Your Ref: OWPC20563
Our Ref: LU/290/18/PDH 10-10-2018
Please ask for:
Zac Denton

Town and Country Planning Act 1990 (As amended)
Town and Country Planning (General Permitted development) Order 2015 Schedule 2 Part 1
Class A

Notification under extended permitted development rights for rear sun room extending 4m from the original rear wall of the dwelling house, 3.5m high with an eaves height of 2.4m
108 Manning Road Littlehampton

PROPOSED REAR SUNROOM

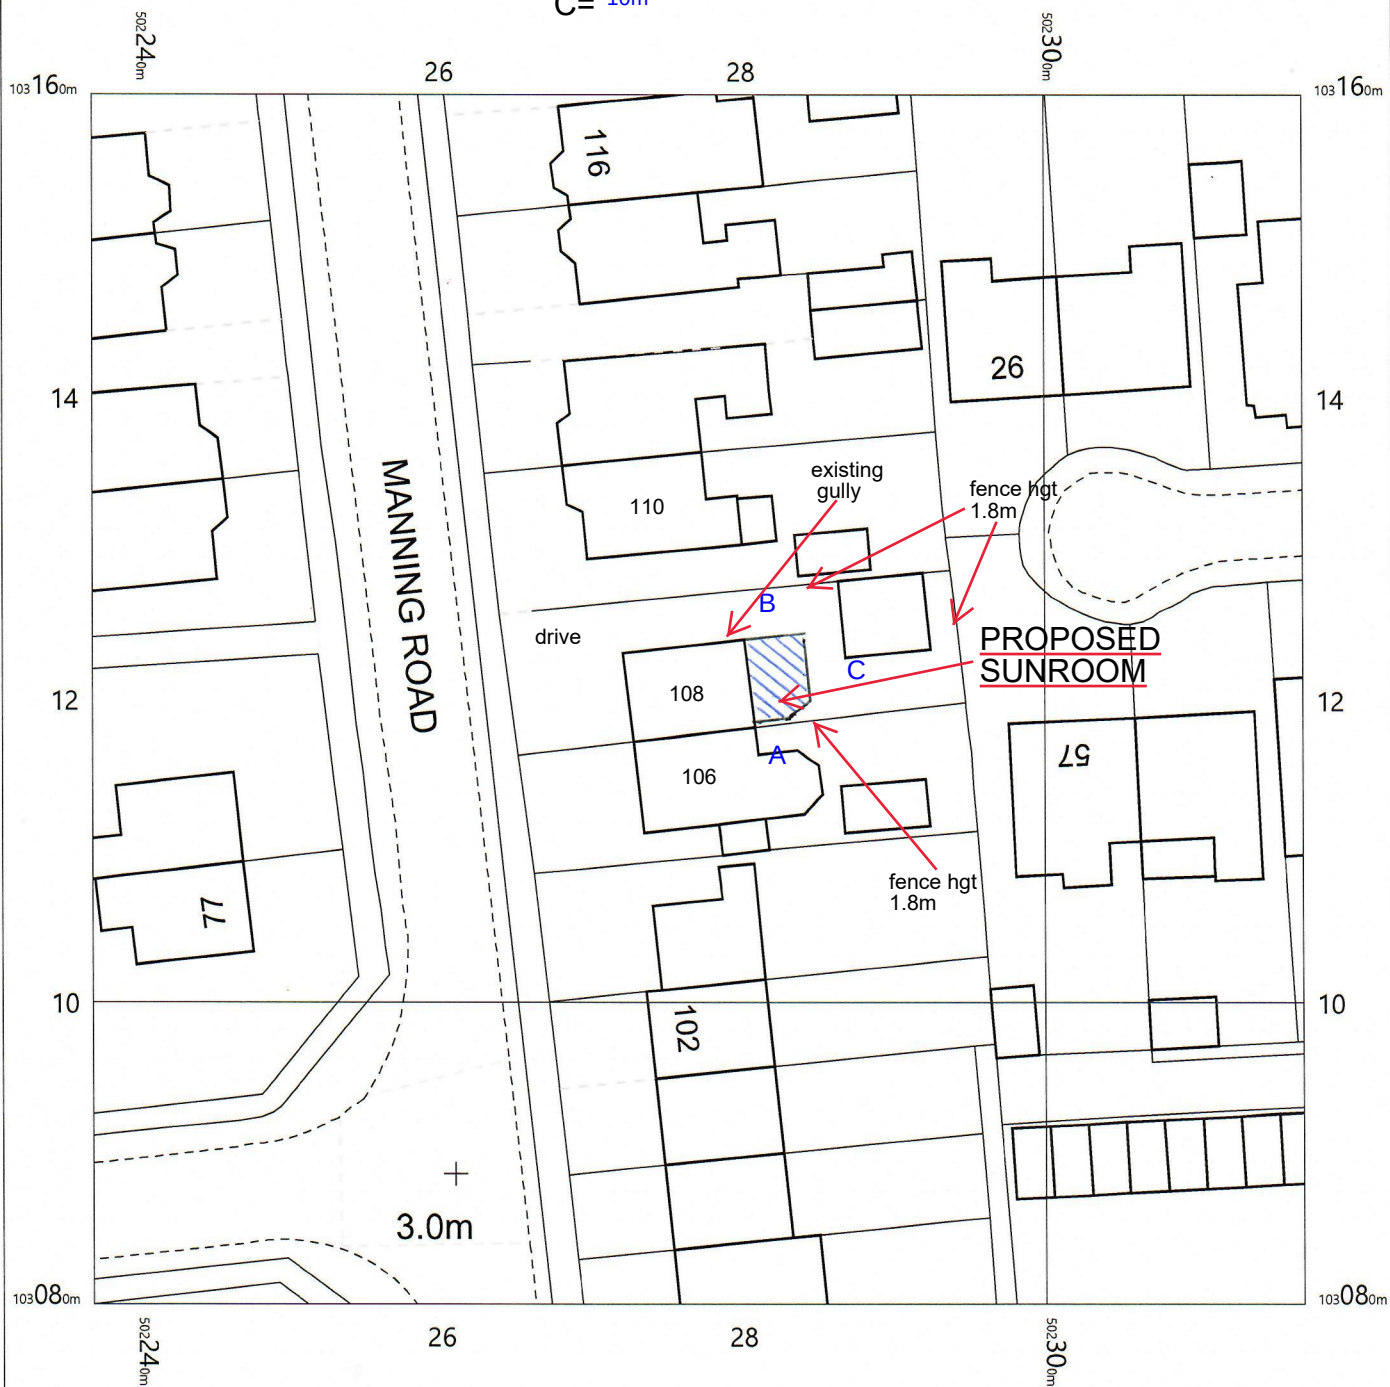
I am concerned over the width of the extension/sunroom. It is almost 20ft which appears to be far too close to the boundary line of our property. This plan does not indicate where the manhole to the shared drains are. In particular, the one that overlaps the boundary line. Our existing wall was built on our land free from the actual boundary line. We must insist that any structure built next door should likewise be free from the actual boundary line; nor would we agree that the above mentioned manhole to the shared drains be built over by any structure preventing ease of access to said drain. Also, there is no mention of where the drains are and I do not see any sign of dwarf walls on the plan.
